BEN LOMAND MOUNTAIN VILLAGE

LANDSCAPE SITE PLAN

Landscape Plans

El Paso County, Colorado

LANDSCAPE PLAN 5.A

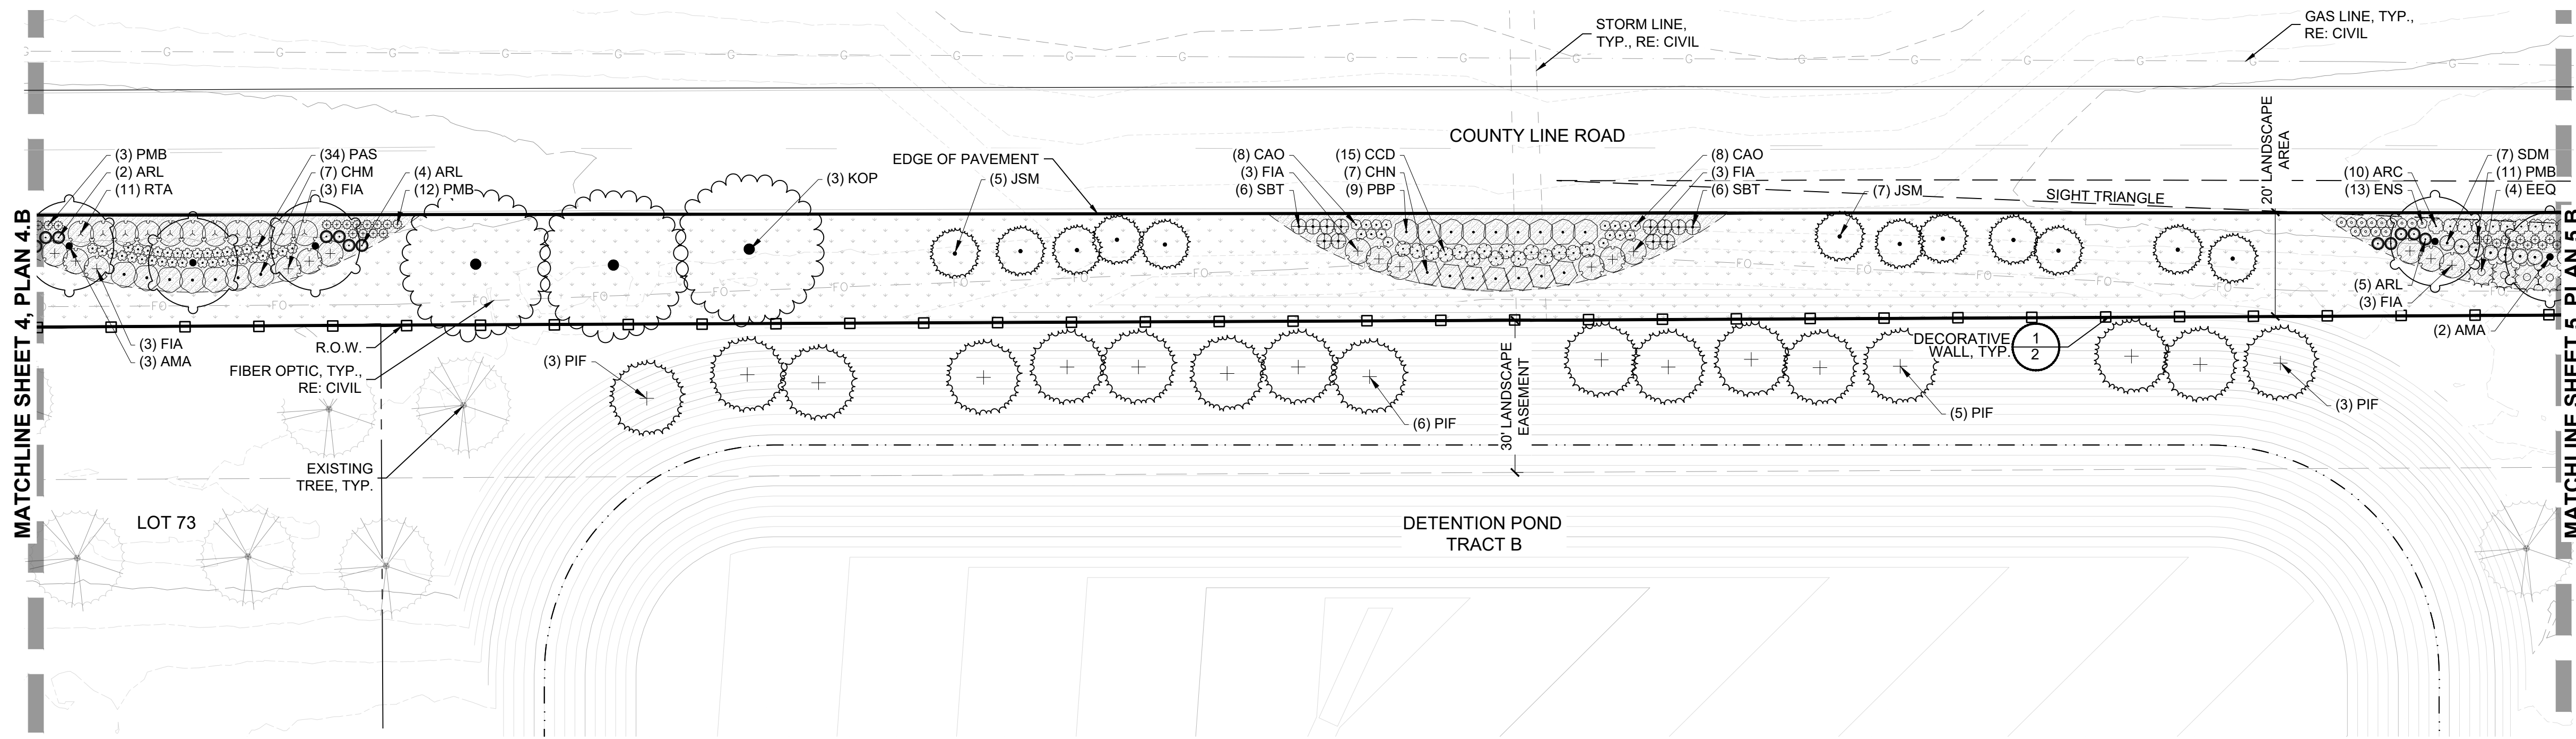
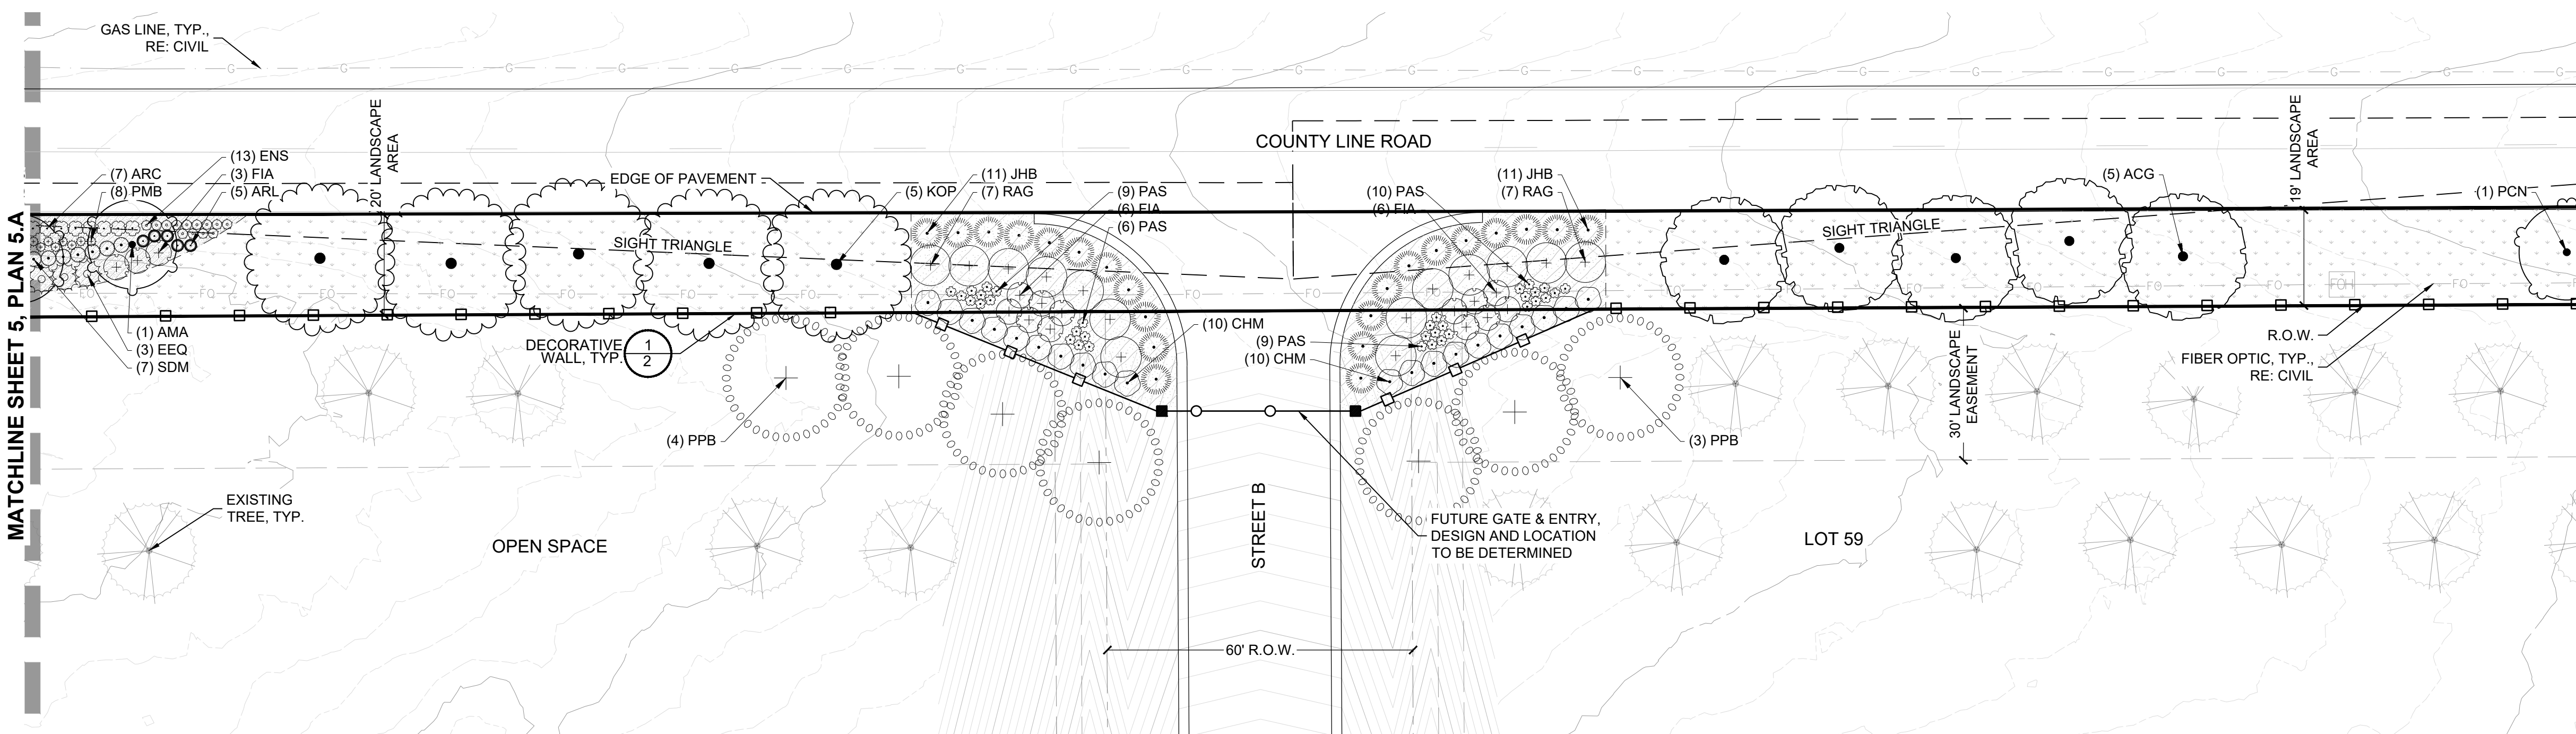
Typical comments to the three access intersections along County Line Road.
Shrubs shall not be taller than 30 inches from the flow line on all three the intersection.
Trees canopies must moved out the right and left Sight Triangles.
